13 May 2014

Planning Application Ref. WSCC/096/F/13 (Development and Operation of a Waste Treatment Facility) at the New Circular Technology Park (Former Ford Blockworks), Ford Airfield Industrial Estate, Ford, Arundel, West Sussex, BN18 0HY

Additional Clarifications

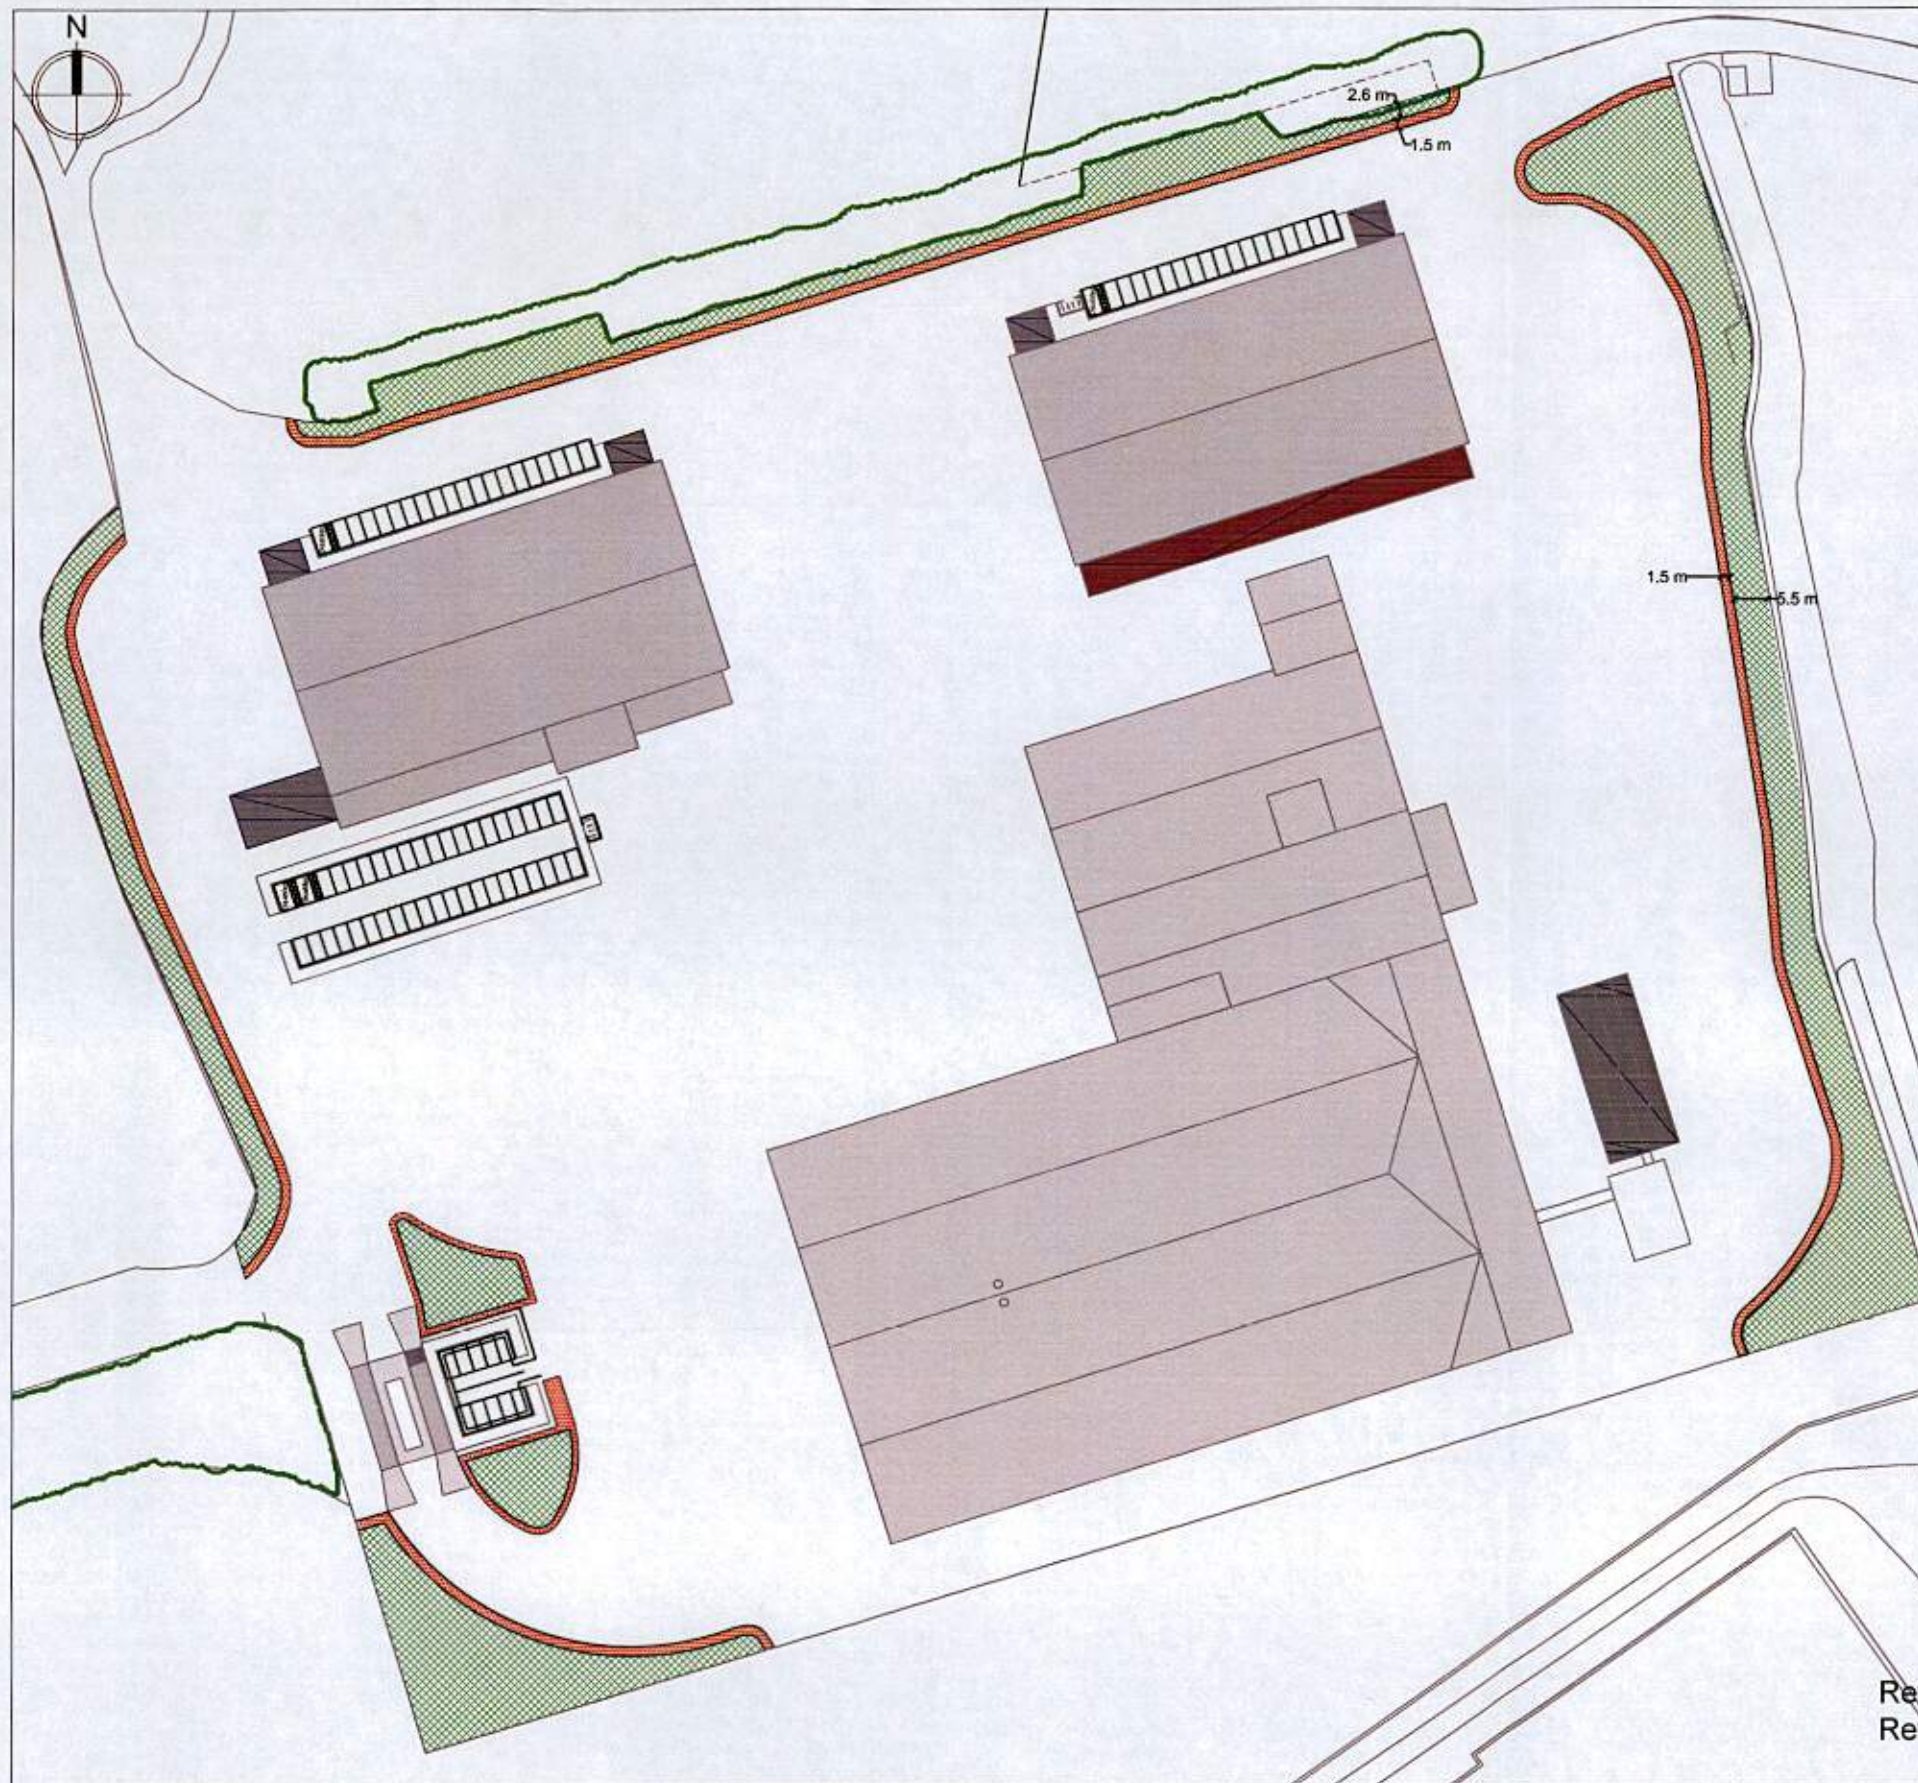
As suggested in your email, we have reviewed our landscape scheme, particularly in relation to the provisions alongside the northern and eastern boundaries of the site, and the revised proposals (see enclosed drawing no. SHF.049.003.D.001 rev. A) now include further planting alongside these two boundaries.

The additional planting (particularly alongside the northern boundary) has been provided in such a way that it will not hinder the internal traffic circulation within and at the periphery of the site.

We confirm that this additional planting lies fully within the Application Site and land owned by the Applicant. This will provide some degree of visual screening of the Application Site and will be planted and maintained by the Applicant.

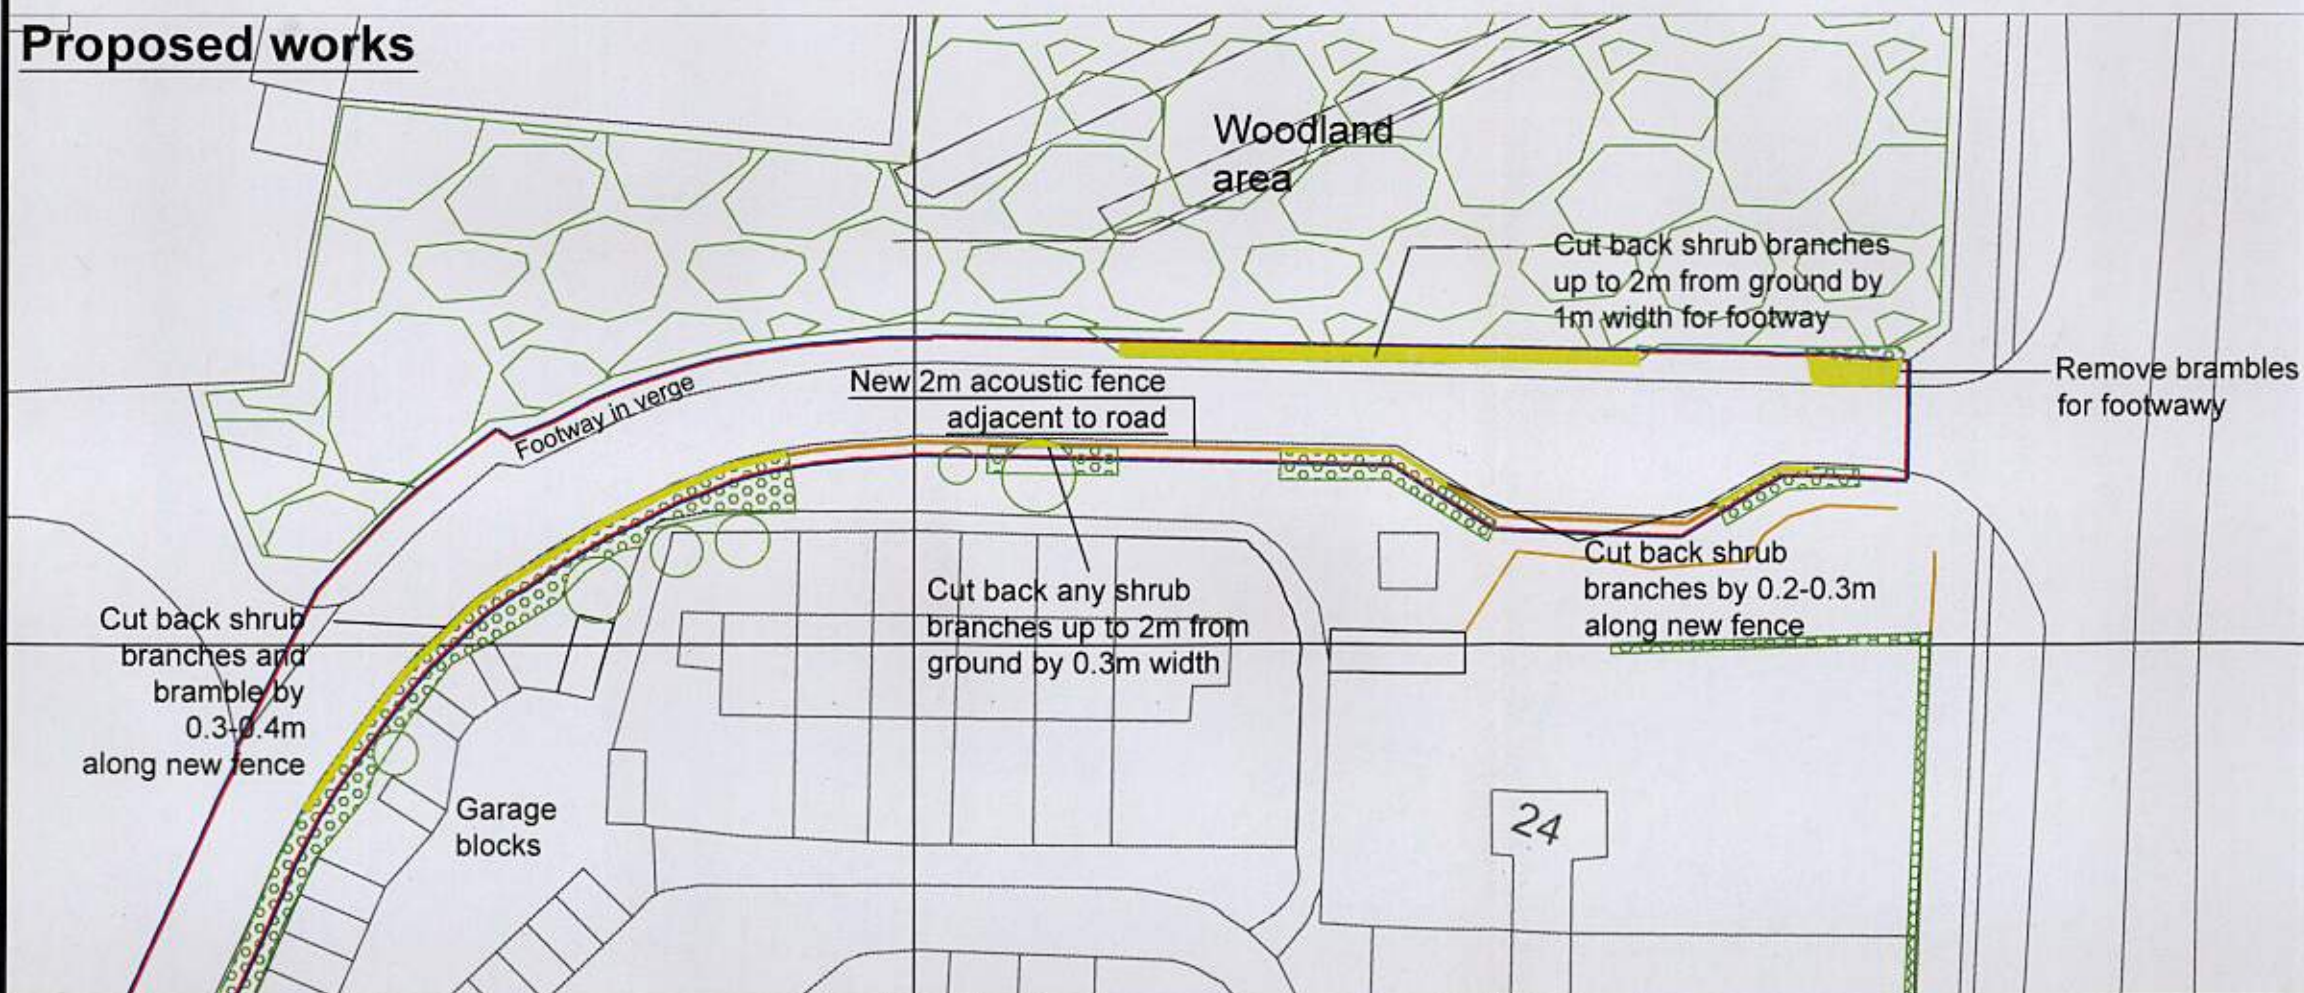
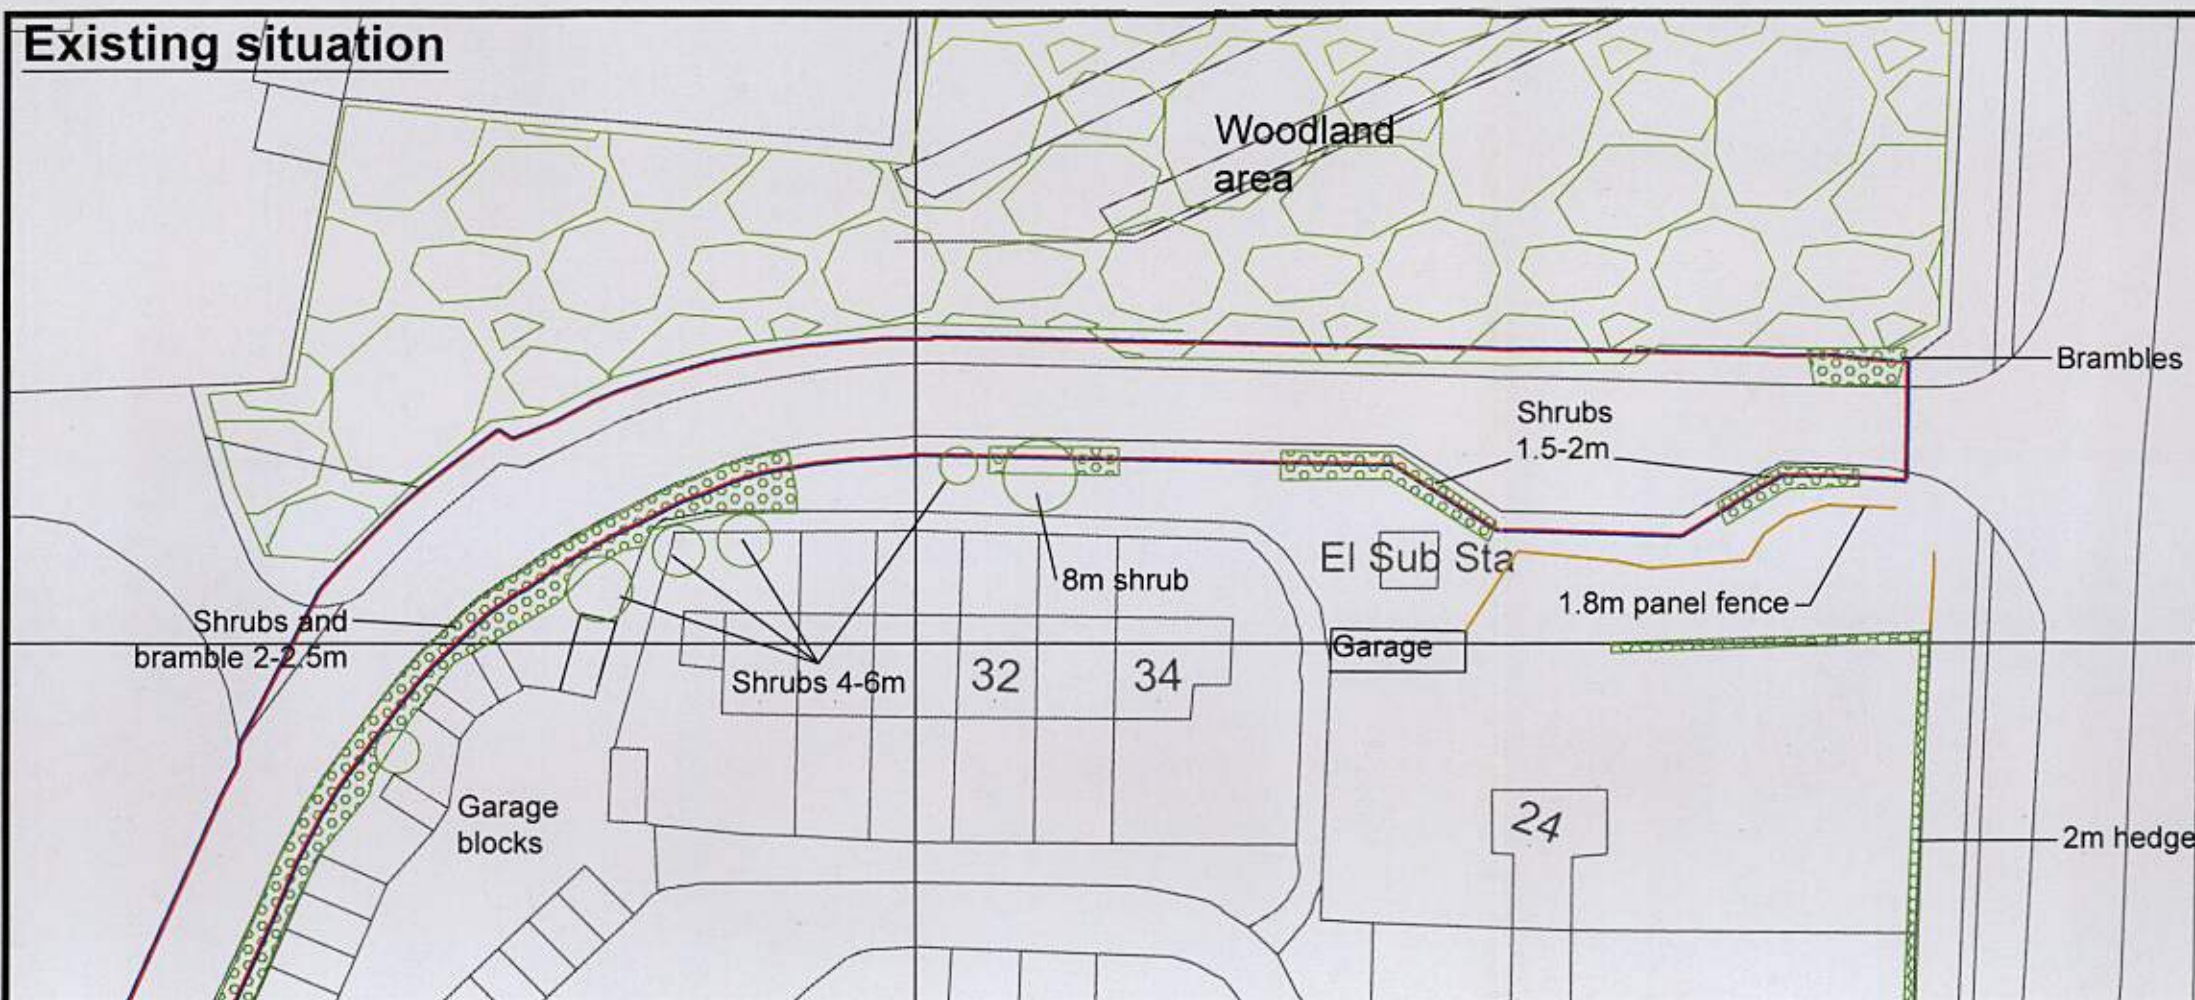
As you are aware, we are proposing to erect a 2m high acoustic fence on the eastern access road opposite to the residential properties of Rodney Crescent.

We would like to clarify that the acoustic fence will be erected within land in control of the Applicant. The vegetation clearance necessary in order to install the fence is expected to be nominal. Notwithstanding this, we confirm that any vegetation that needs to be removed as part of these works, particularly to the southern side of the fence, will be replaced as far as practicable upon completion.
